DECISION DELEGATED TO HEAD OF PLANNING

Application No: H08-0718-24 **Applicant:** Mr M Yould

Proposal: Details of external materials, landscaping & tree planting, boundary treatment, foul water disposal and soakaway system for the disposal of surface water (Conditions 3, 5, 6, 7 and 8 of H08-1160-18)

Location: 124 Siltside Gosberton Risegate Spalding

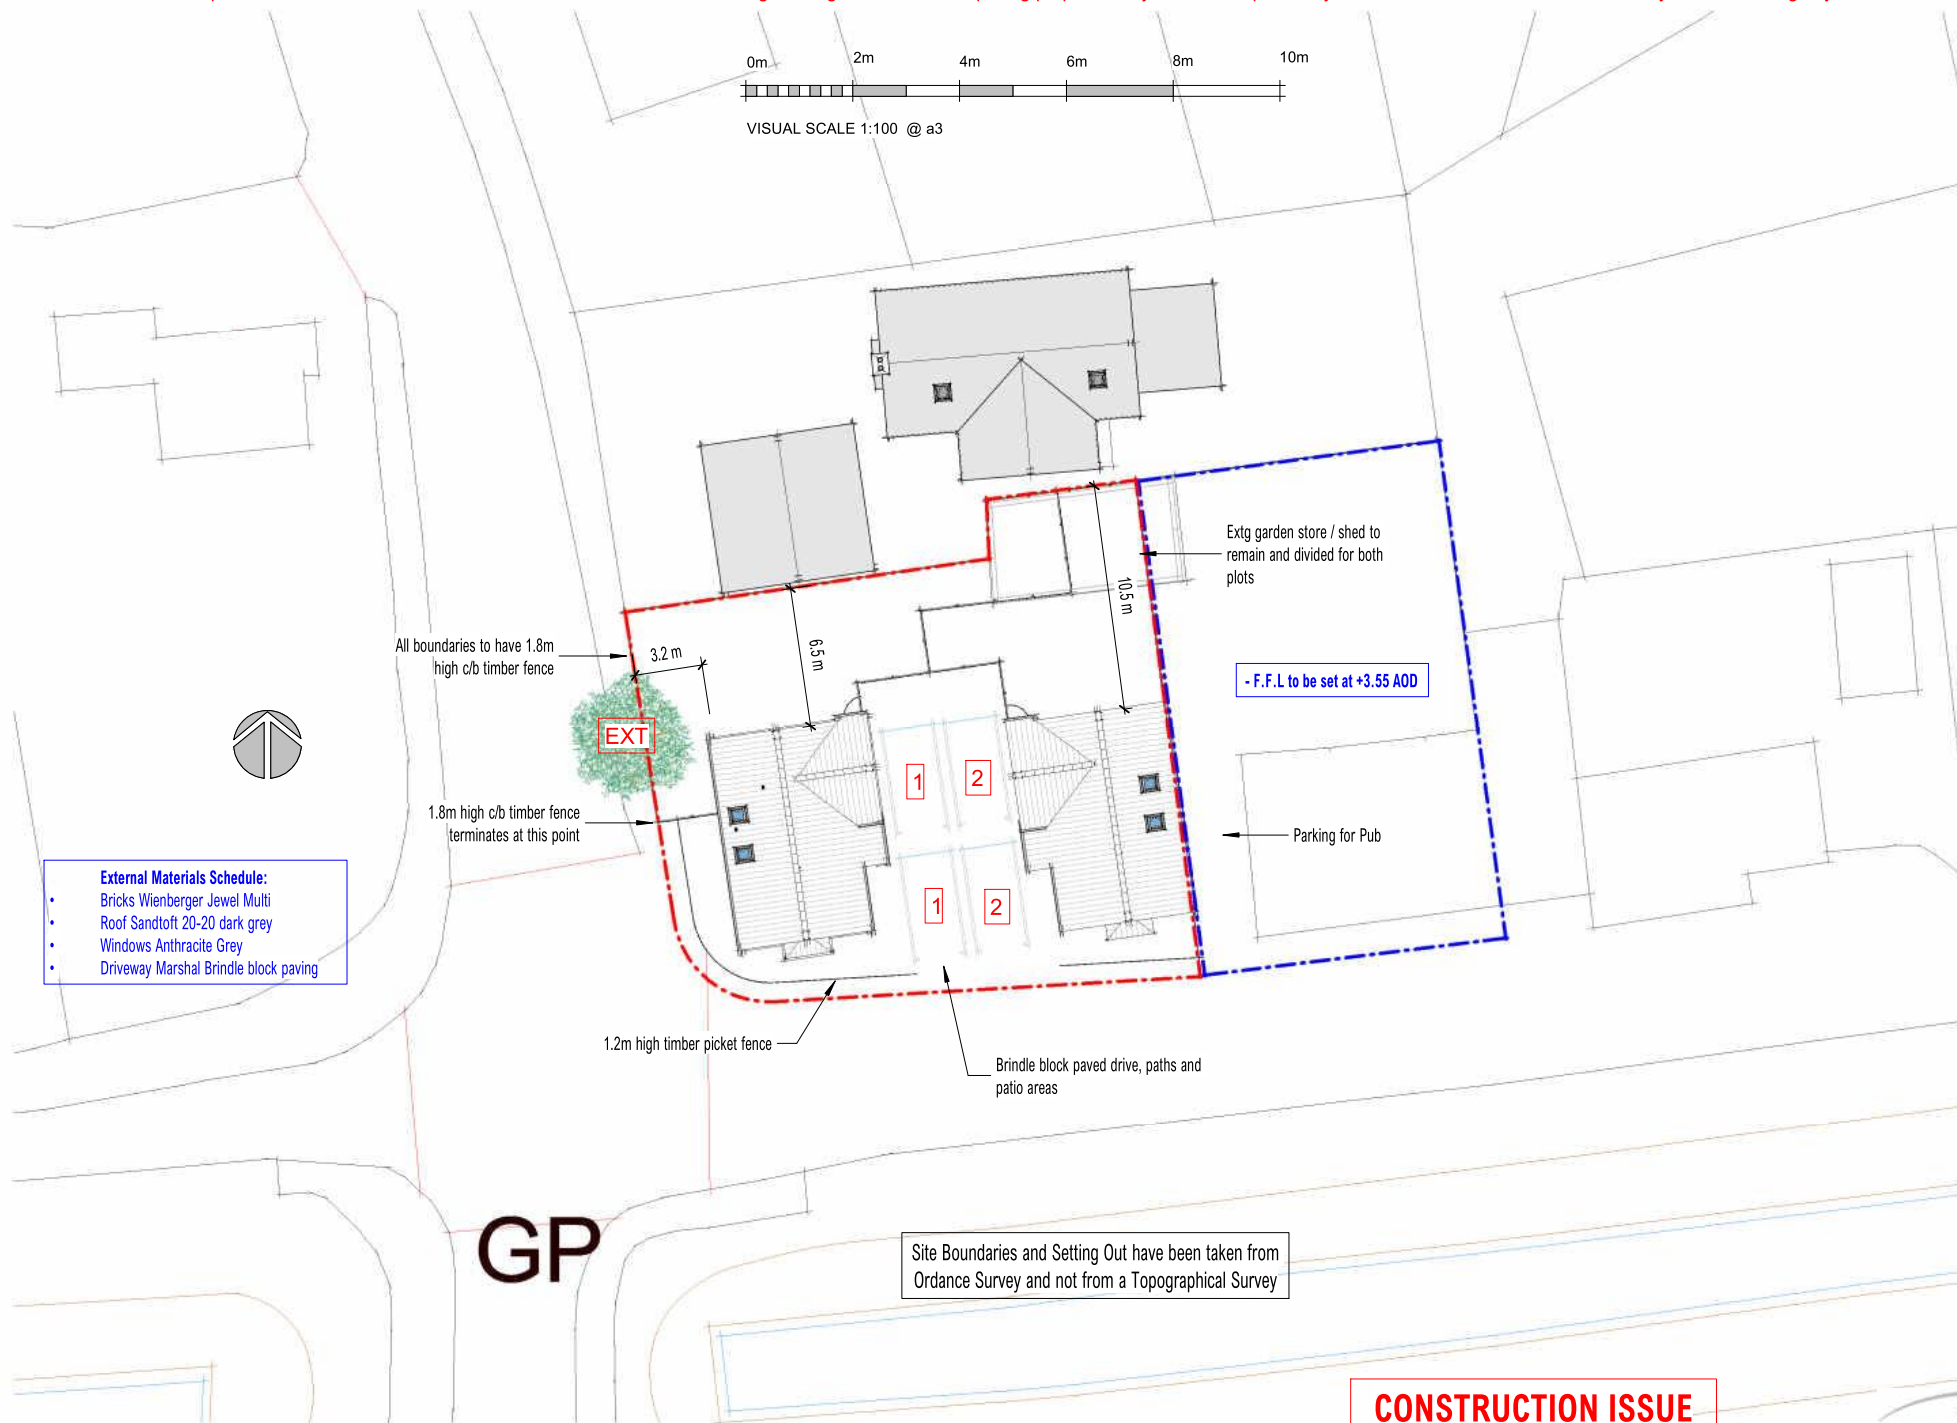
The proposed materials are considered acceptable given the wide variety of materials present in the street. Brindle block paving is proposed for the drive, paths, and patio areas.

The submitted plan shows very minimal landscaping and tree planting for the site. The gardens are to be lawned with a proposed 300mm high boxed hedge to the front boundary. Although minimal the landscaping details are considered to be acceptable and condition 5 can therefore be discharged.

To the southern boundary a 1.2m picket fence is proposed with a 1.8m high fence proposed to the north and east of the site, on the west side of the site the 1.8m high fence terminates half way along the western boundary with a 1.2m high picket fence continuing along the western boundary towards the southern boundary. The submitted details are considered to be acceptable and can therefore be discharged.

Foul drainage to discharge into Klargester BioDisc BA Single Household Domestic Sewage Treatment Plant with overflow discharging into drain, this is considered acceptable, and can therefore be discharged.

Limited details have been provided, in that surface water would be discharged into a drain. Consequently, the Internal drainage Board have made the following comments.

The submitted materials are considered to be in keeping with the character of the area and therefore are acceptable. The condition can be discharged.

The details in respect of surface water drainage are considered to be acceptable. The Welland & Deeping Internal Drainage Board have been consulted and have raised no objections. As such condition 8 can be discharged.
